**Re: Greaves Subdivision Filing No. 1 (VR243) – Replat Comment Response Letter  
MVE Project No. 61211**

**Final Plat:**

## GREAVES SUBDIVISION FINAL PLAT

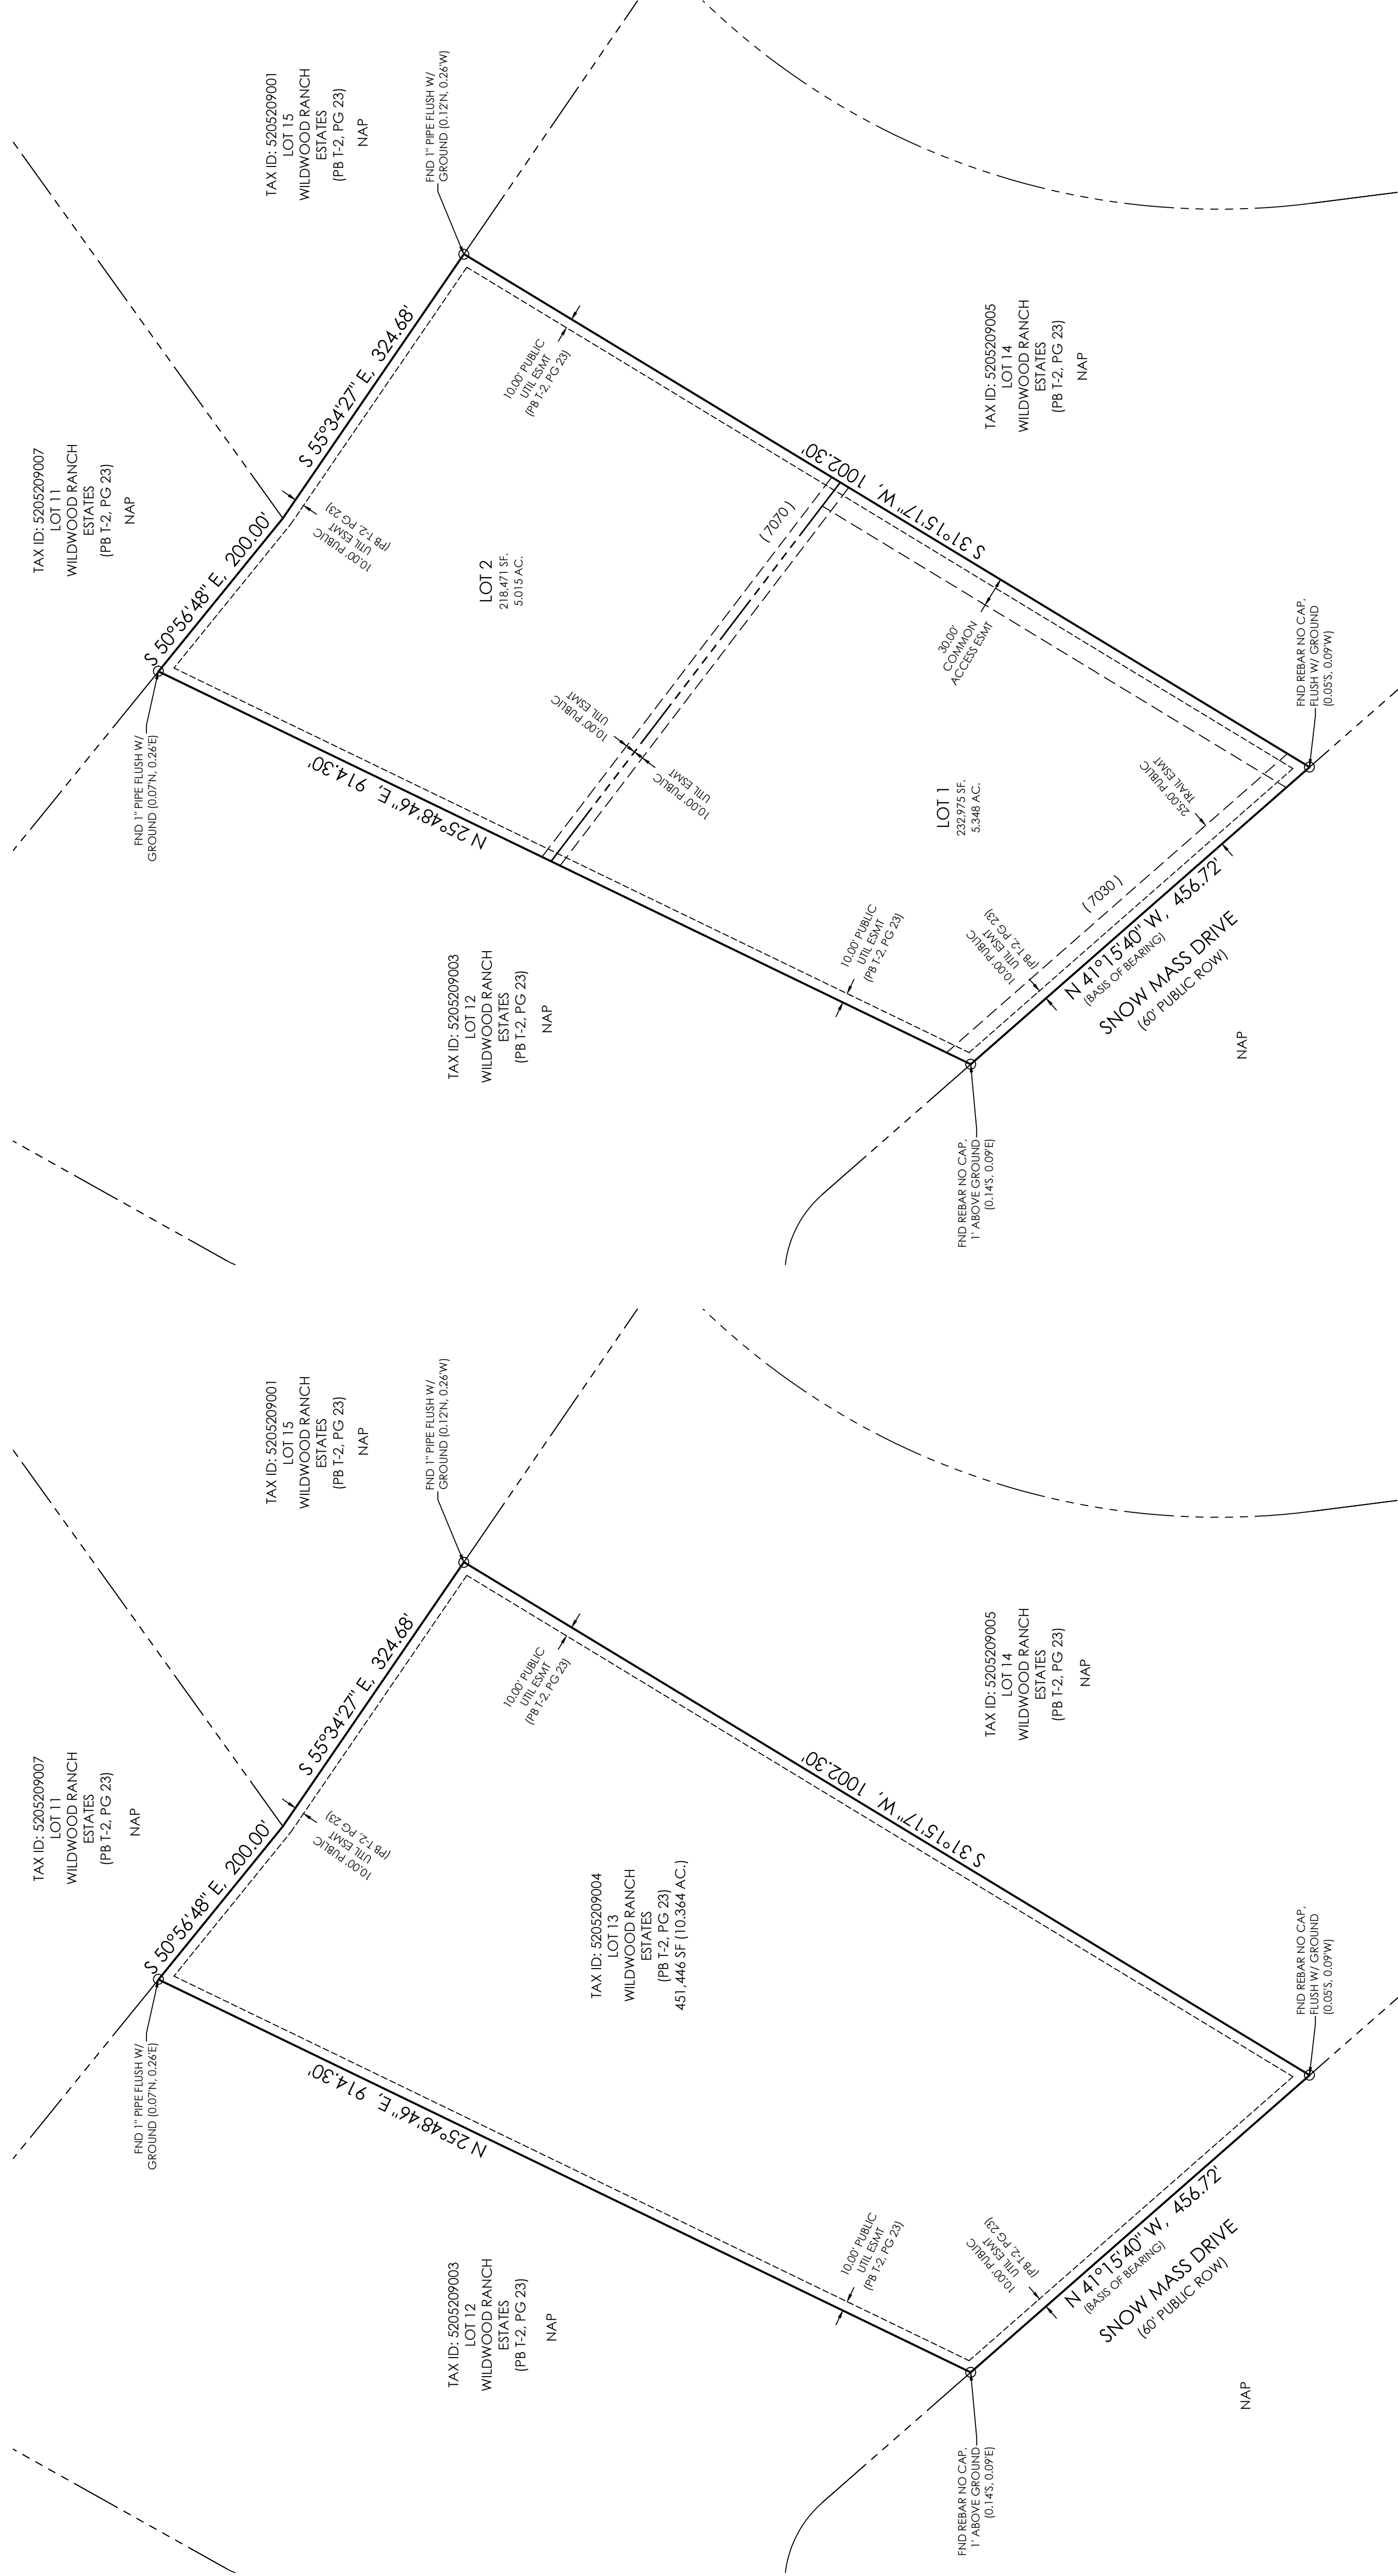
PCD Eng, Comment: “Please include statement below: Unless otherwise indicated, all side, front, and rear lot lines are hereby platted on either side with a 10 foot (use 5 feet for lots smaller than 2.5 acres) public utility and drainage easement unless otherwise indicated. All exterior subdivision boundaries are hereby platted with a 20 foot (use 7 feet for lots smaller than 2.5 acres) public utility and drainage easement. The sole responsibility for maintenance of these easements is hereby vested with the individual property owners.”

MVE Response: A 10 foot public utility and drainage easement is being granted to each side of the new lot line. The existing lot already has a 10 foot easement around its exterior. Replatting an existing lot does not generate the same easement requirements as a new subdivision would around its boundary. We feel the granting of 20 feet around the boundary for the addition of one single family residence is unwarranted. The easement note was revised to just grant 10 feet along each side of all lots.
